PLAT EXHIBIT COVER SHEET

This Plat Exhibit has been prepared in support of a Plat Note Waiver request for 7981 Fort Smith Road (Lot 593, Woodmen Hills Filing No. 9). Attached to this plat exhibit cover sheet are:

WOODMEN HILLS FILING No.9

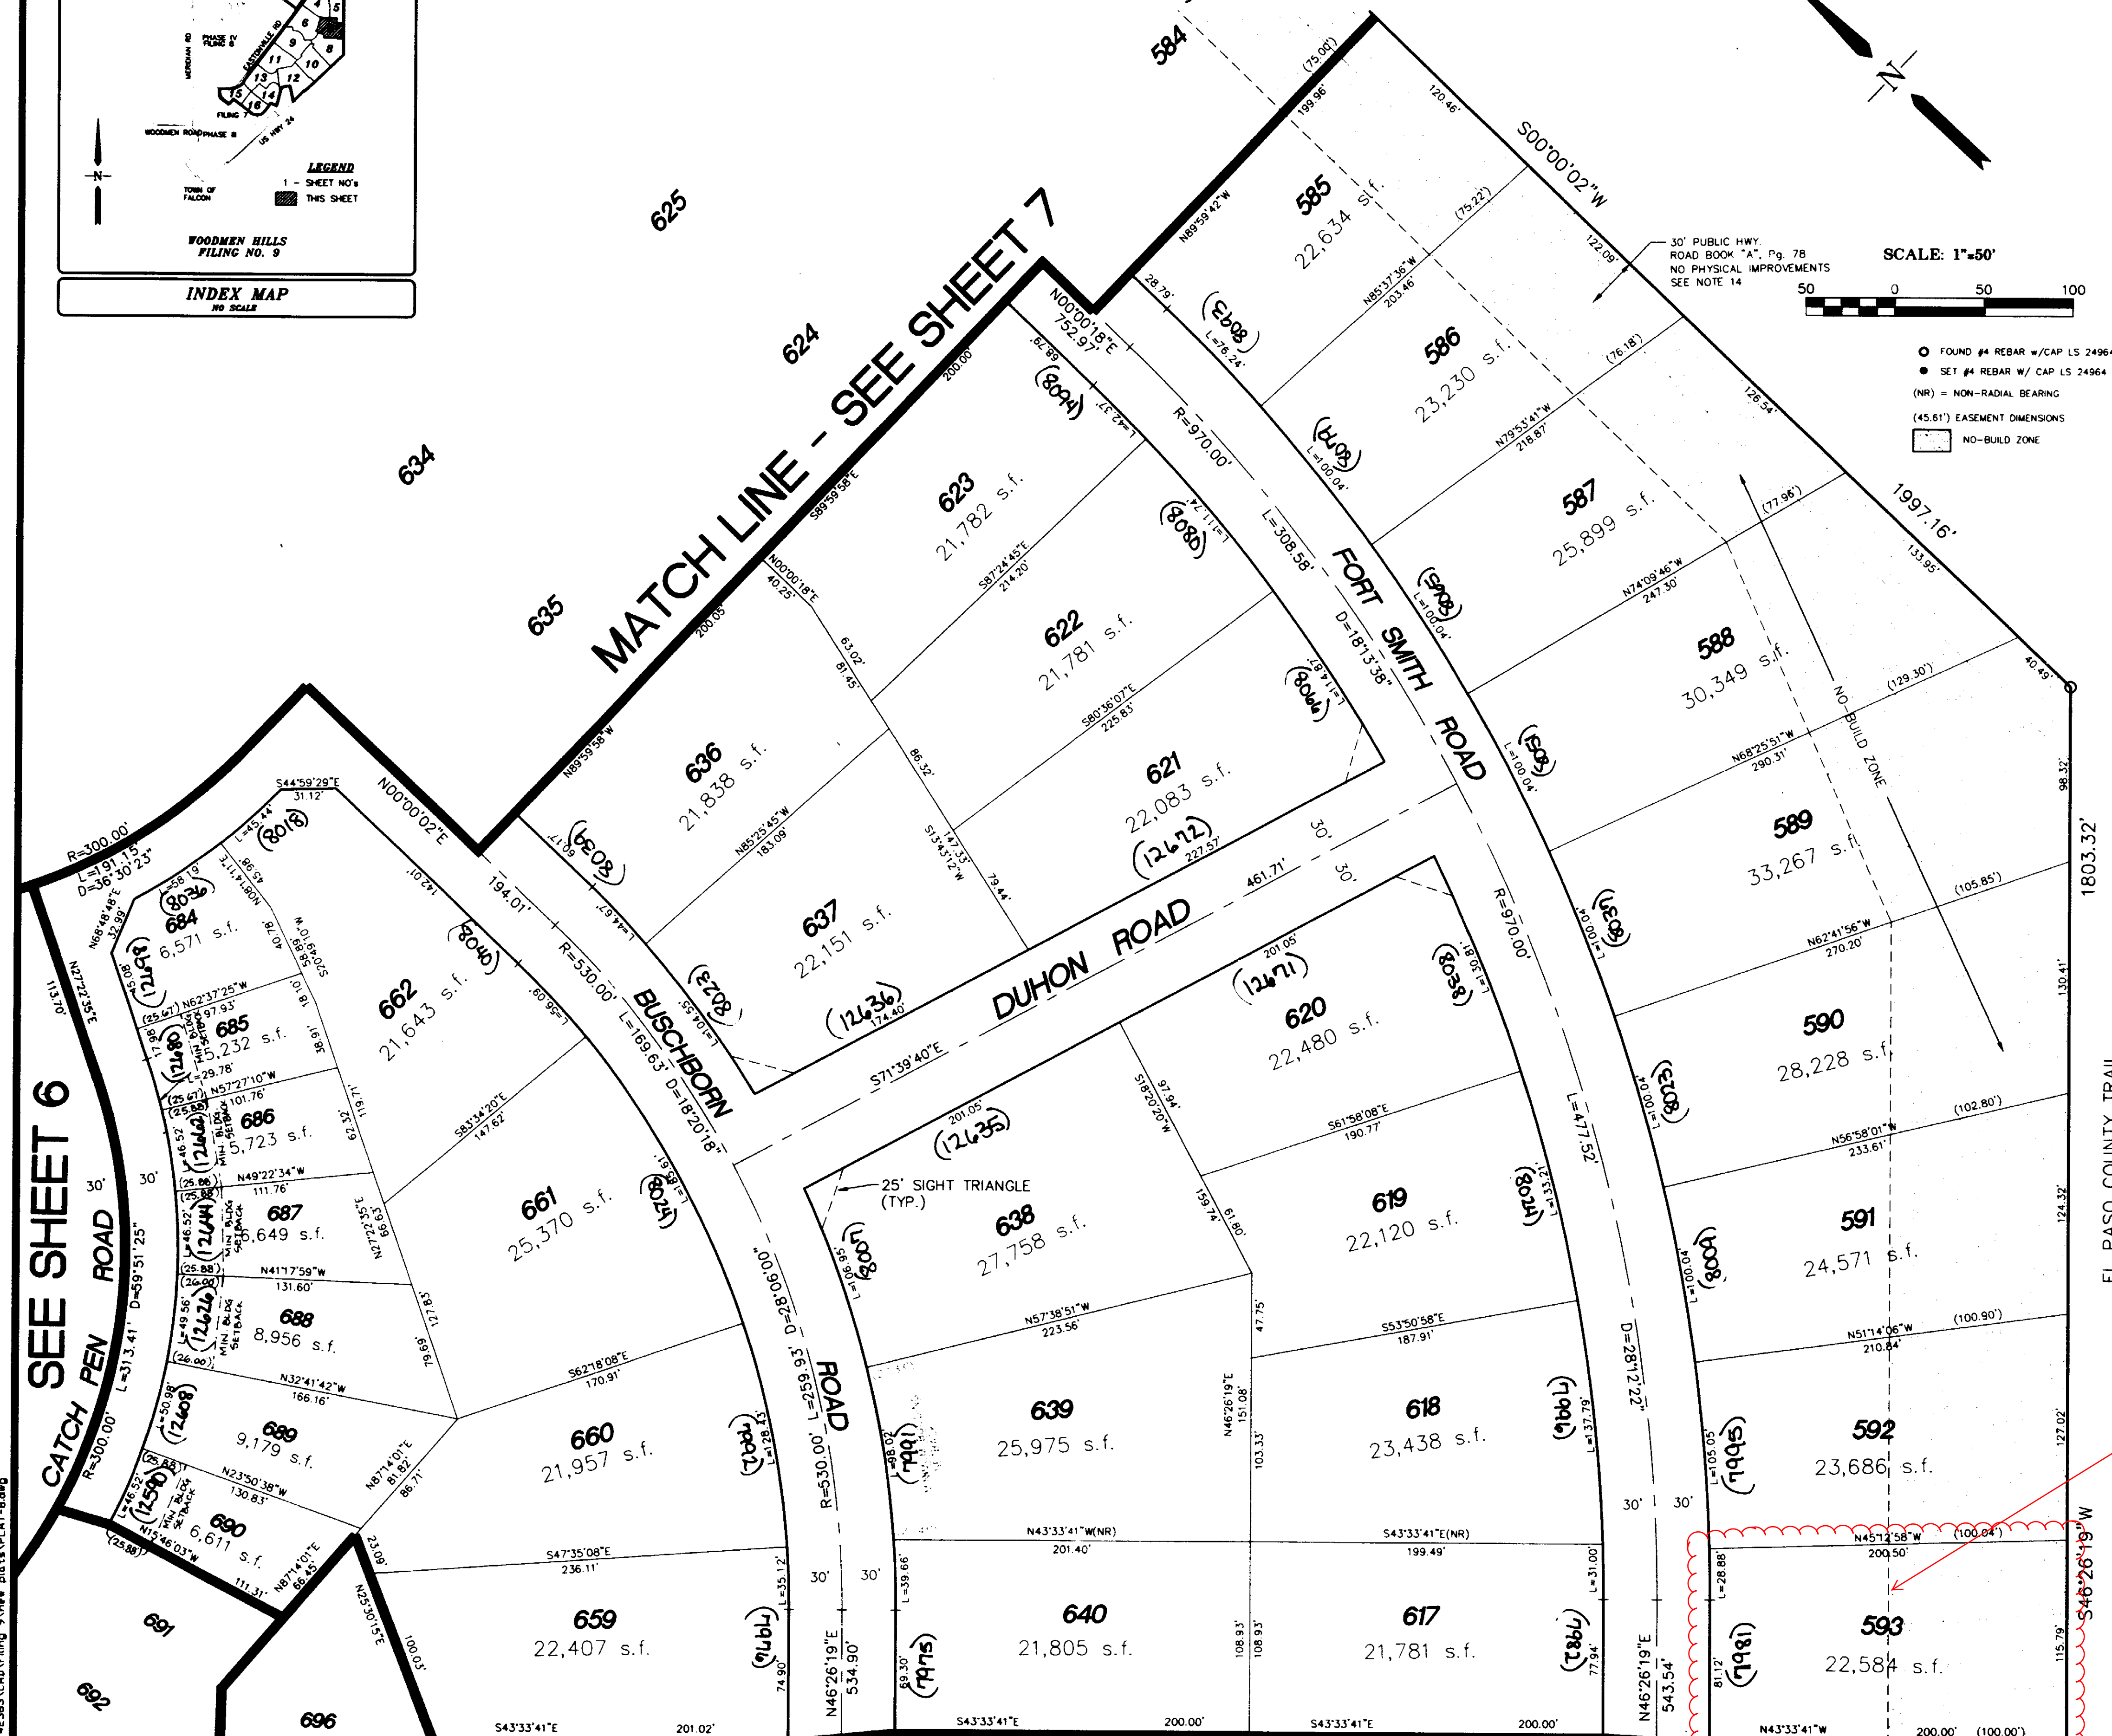
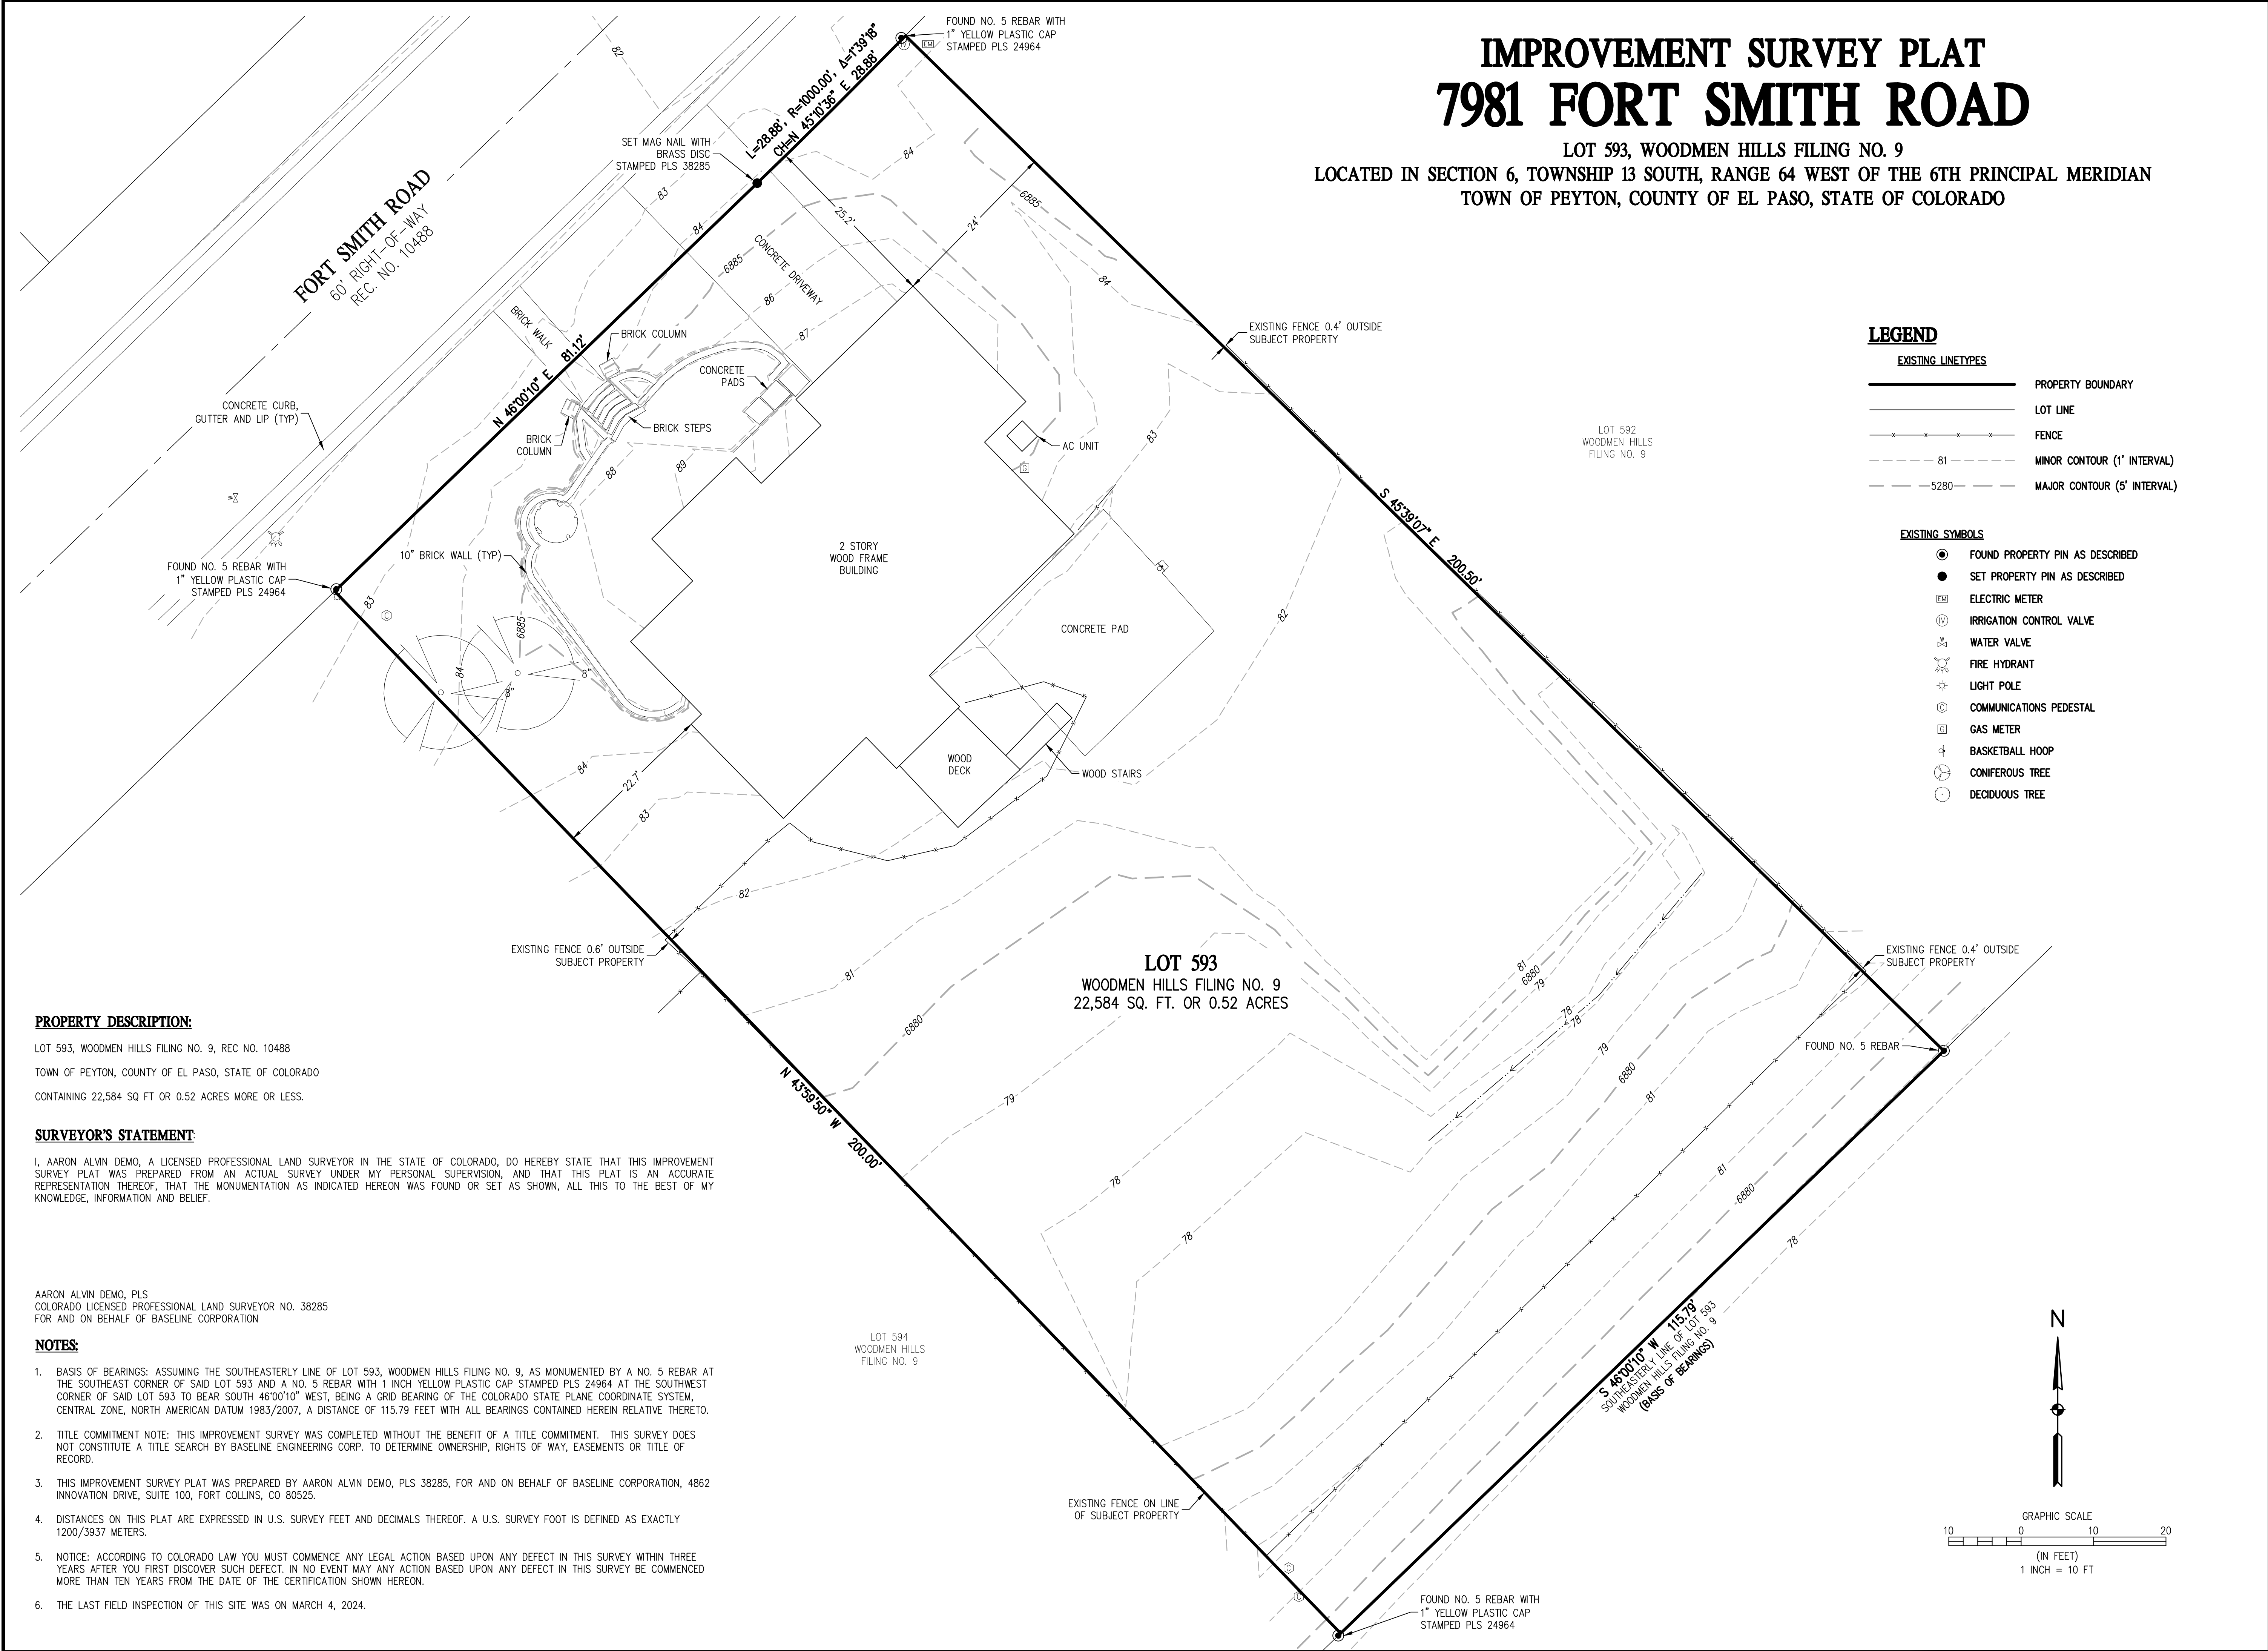
Please redraw the No-build line for lot 593 to fit the new proposed contours and do not remove entirely. Engineering requests to amend the No-build zone to become a drainage easement with a restriction of no-build and no storage of materials in the drainage way, while allowing for the proposed structure to be built.

Please add the additional note:

3) All fencing built along lot lines within the No-Build zone shall be limited to the installation of split rail fence only.
